**Planning Act 2008 – Section 88 and the Infrastructure Planning (Examination Procedure) Rules 2010 – Deadline 5: Comments on Coastal Geomorphology Reports**

**Application by NNB Generation Company (SZC) Limited for an Order Granting Development Consent for the Sizewell C Project**

## Appendix A: Environment Agency comments on Terrestrial Ecology Reports

DRAWING NO:	REVISION:	
SZC-SZ0100-XX-000-DRW-100207	02	
DATE:	DRAWN:	SCALE:
JULY 2021	CGK	AS SHOWN @ A1

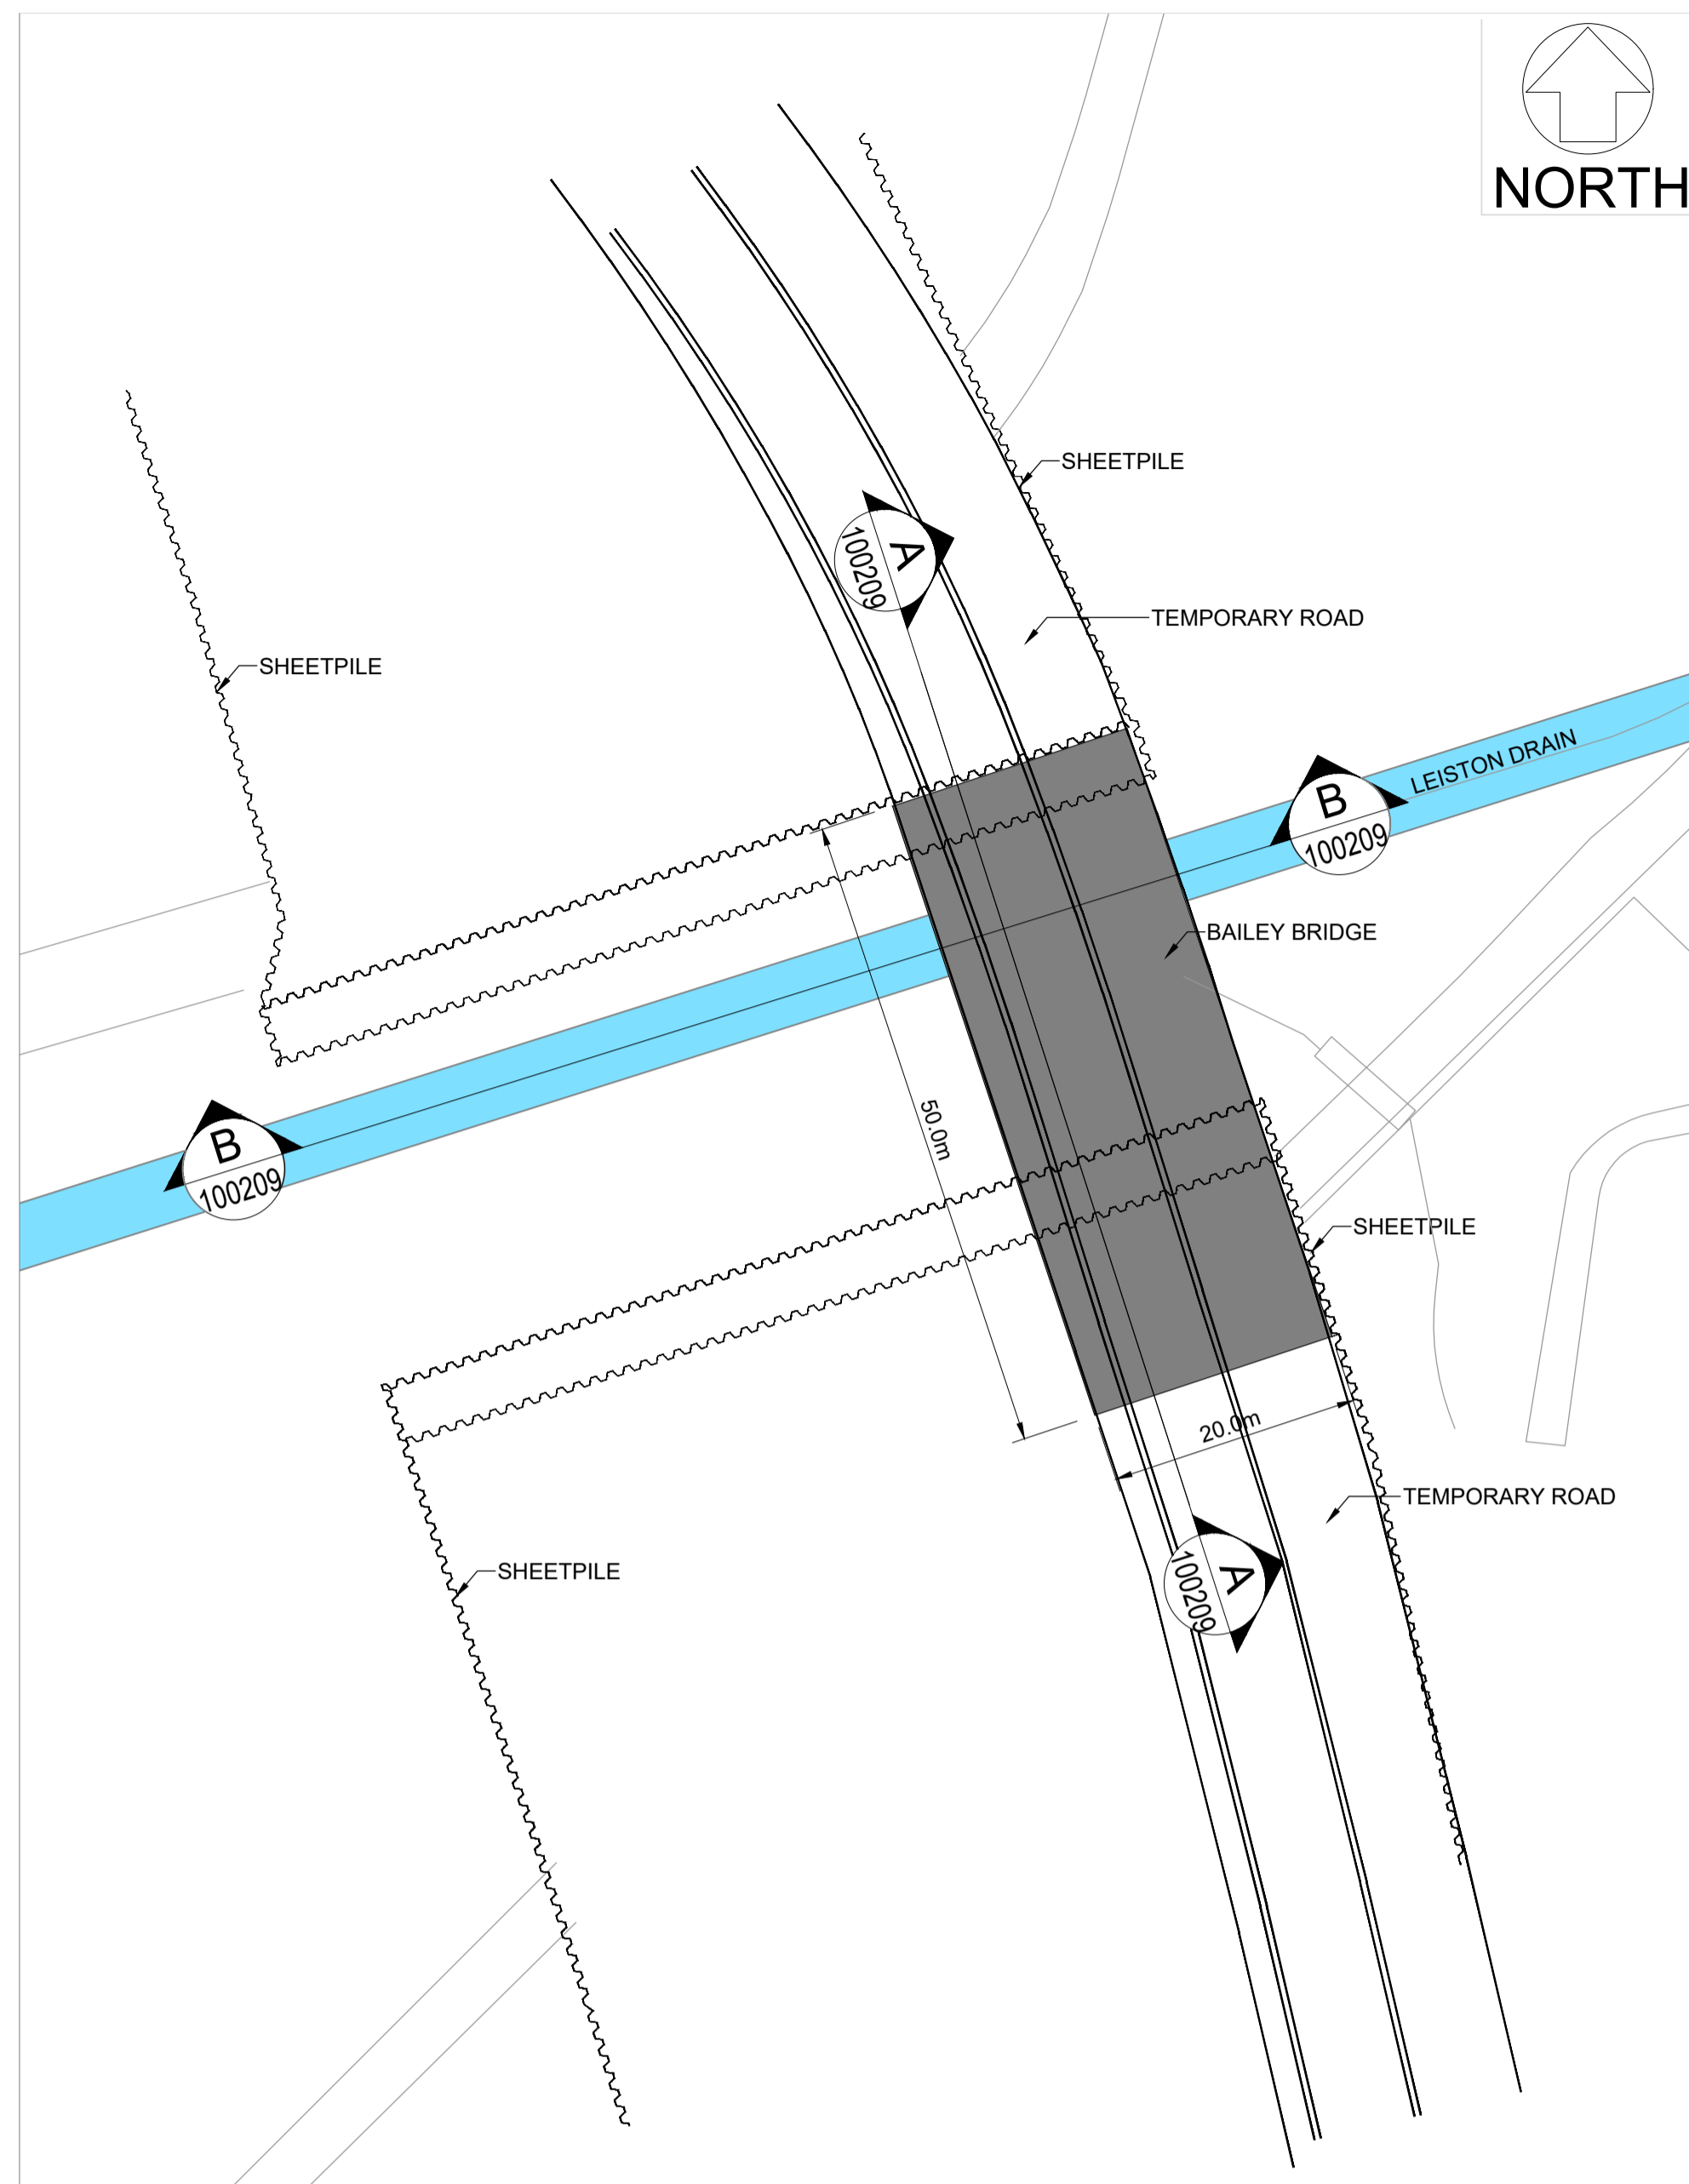
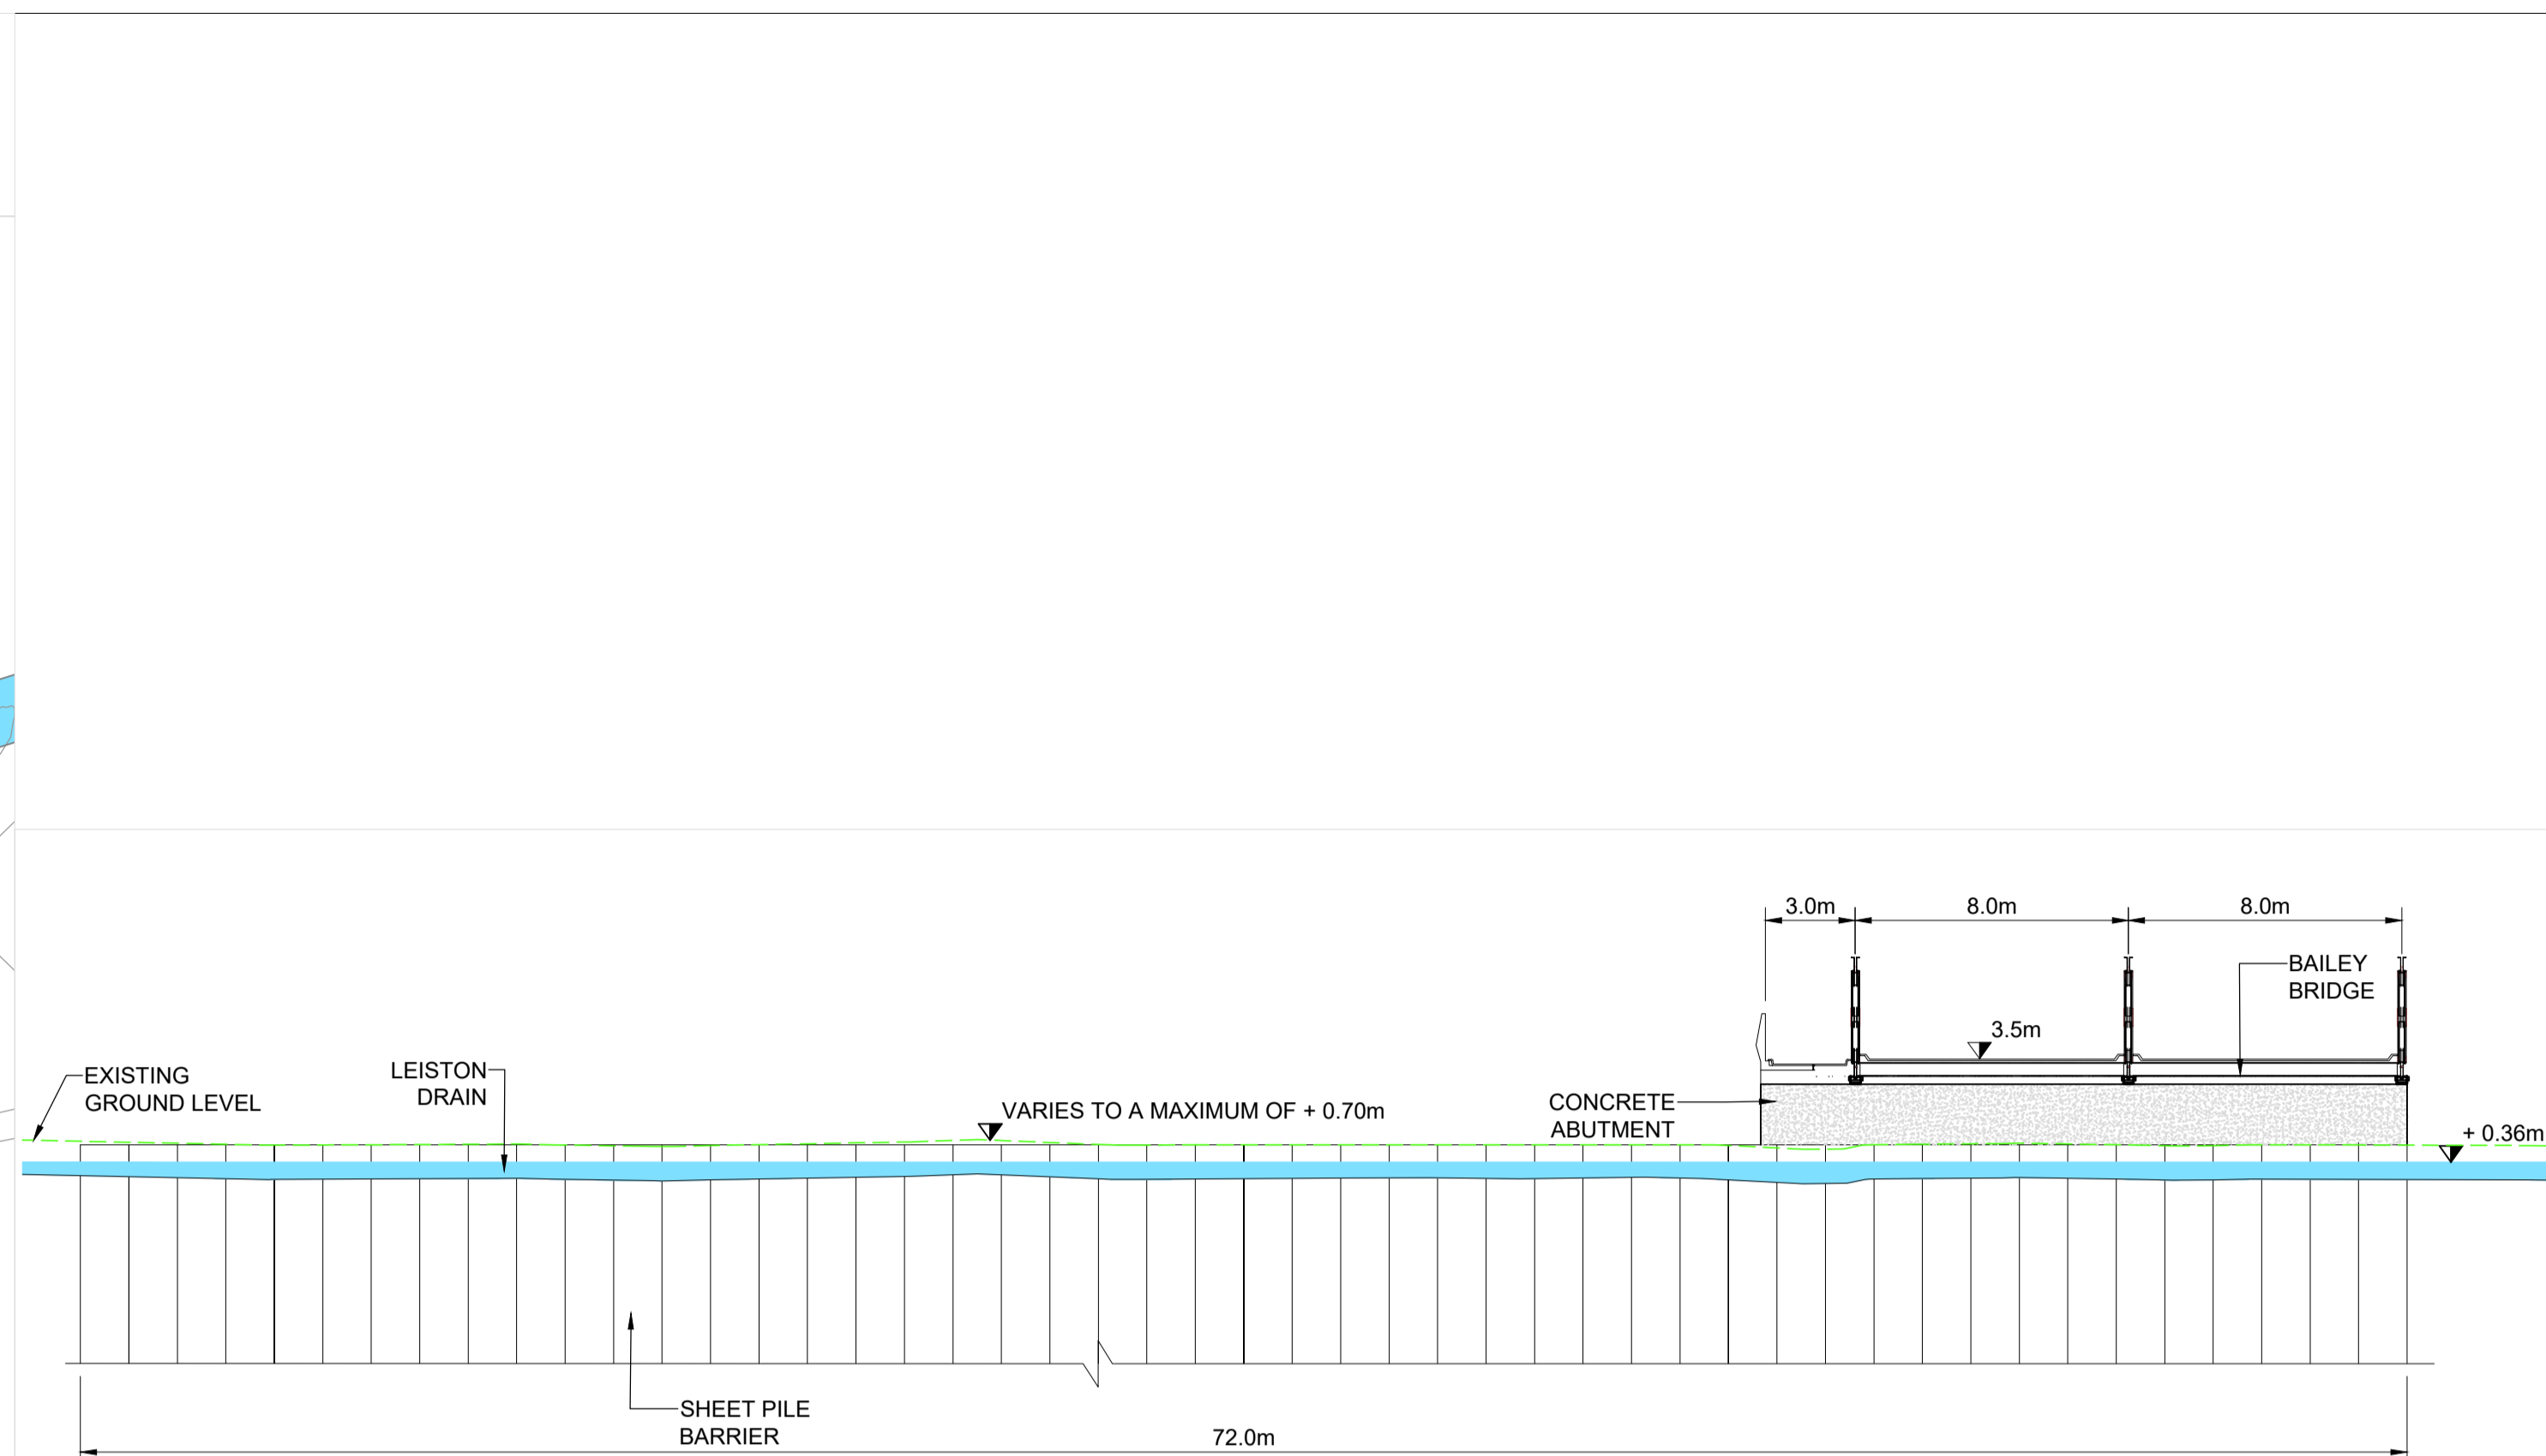
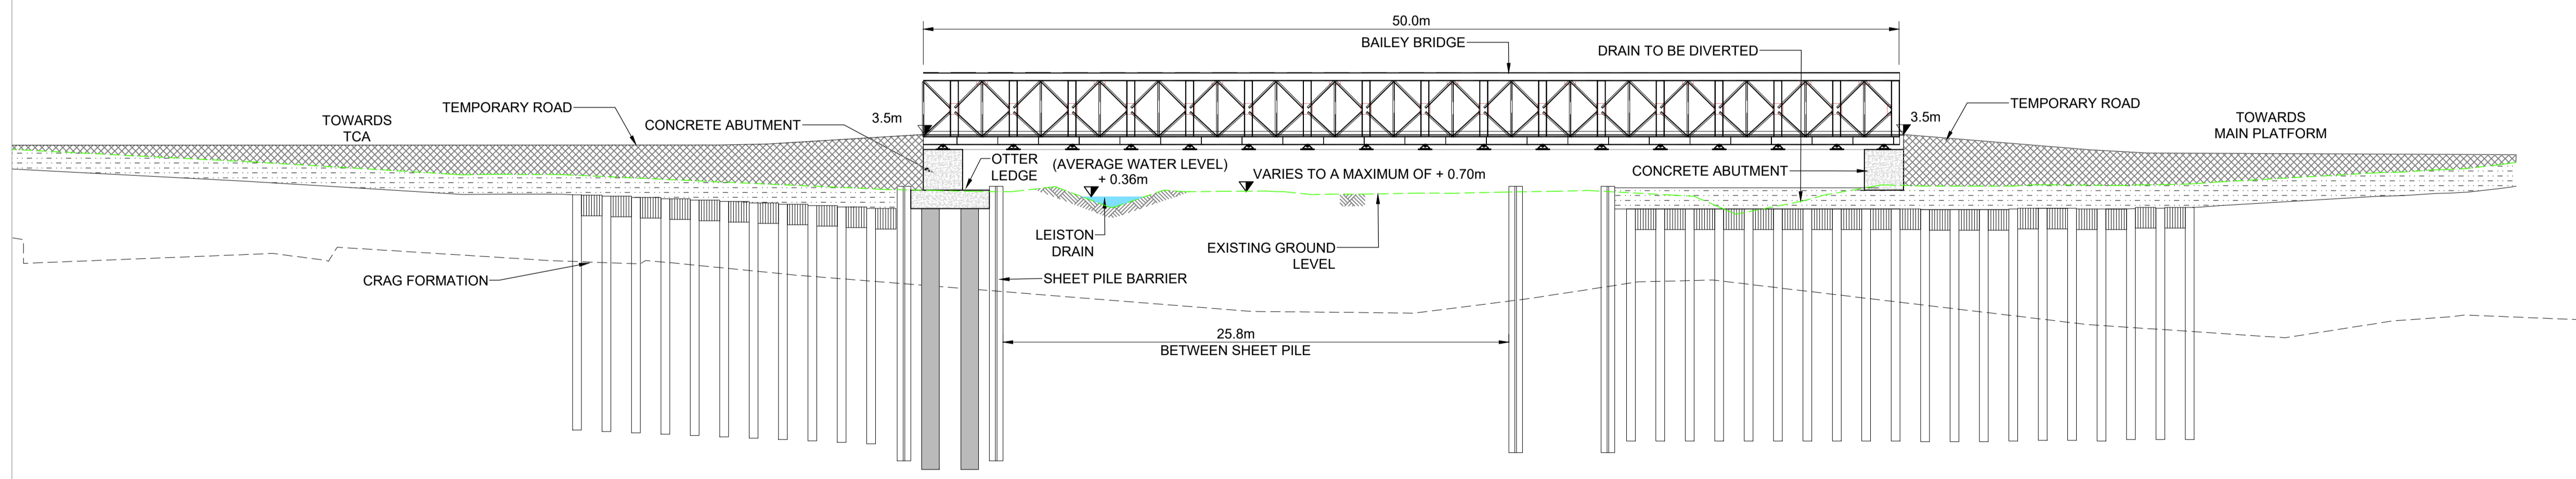
SZC-SZ0100-XX-000-DRW-100207	The SSSI crossing design option proposed for the construction phase shows a drainage pipe under the crossing sited at 5m above the Leiston Beck. This drainage pipe will negate	The proposed SSSI crossing design optimisation of raising the soffit height to 6.8m above the Leiston Beck is a positive change, as is the reduction of width to 15m post construction, and the inclusion of an ecologically and aesthetically acceptable colour scheme. Presently the applicant has	Provide a SSSI crossing design that provides a clearance from the Leiston Beck to the soffit of the crossing of 6.8m for

<p>the positive change from raising the soffit height and would reduce the clearance under the crossing down to 5m, which we consider to be unacceptable, this would not reduce the risk of deterioration to invertebrates to an acceptable level.</p>	<p>submitted different SSSI crossing design drawings for the construction phase and the operational phase. The option proposed for the construction phase shows a drainage pipe under the crossing sited at 5m above the Leiston Beck. The drainage pipe needs to be removed so that a clearance of 6.8m can be achieved for the entire construction phase, rather than being an adaptive measure that is made for the operational phase. If the drainage pipe is not relocated it will negate the positive change achieved from raising the soffit height and would reduce the clearance under the crossing down to 5m, we consider this to be unacceptable, this would not reduce the risk of deterioration to invertebrates to an acceptable level. Our preferred option remains that of the wide span bridge as this would further reduce impacts to the ecology of the area including invertebrates. The applicant has indicated to us that they will be submitting a revised SSSI crossing design for the construction phase which would remove this drainage pipe at deadline 7.</p>	<p>the entire construction phase rather than being an adaptive measure that is made for the operational phase.</p>
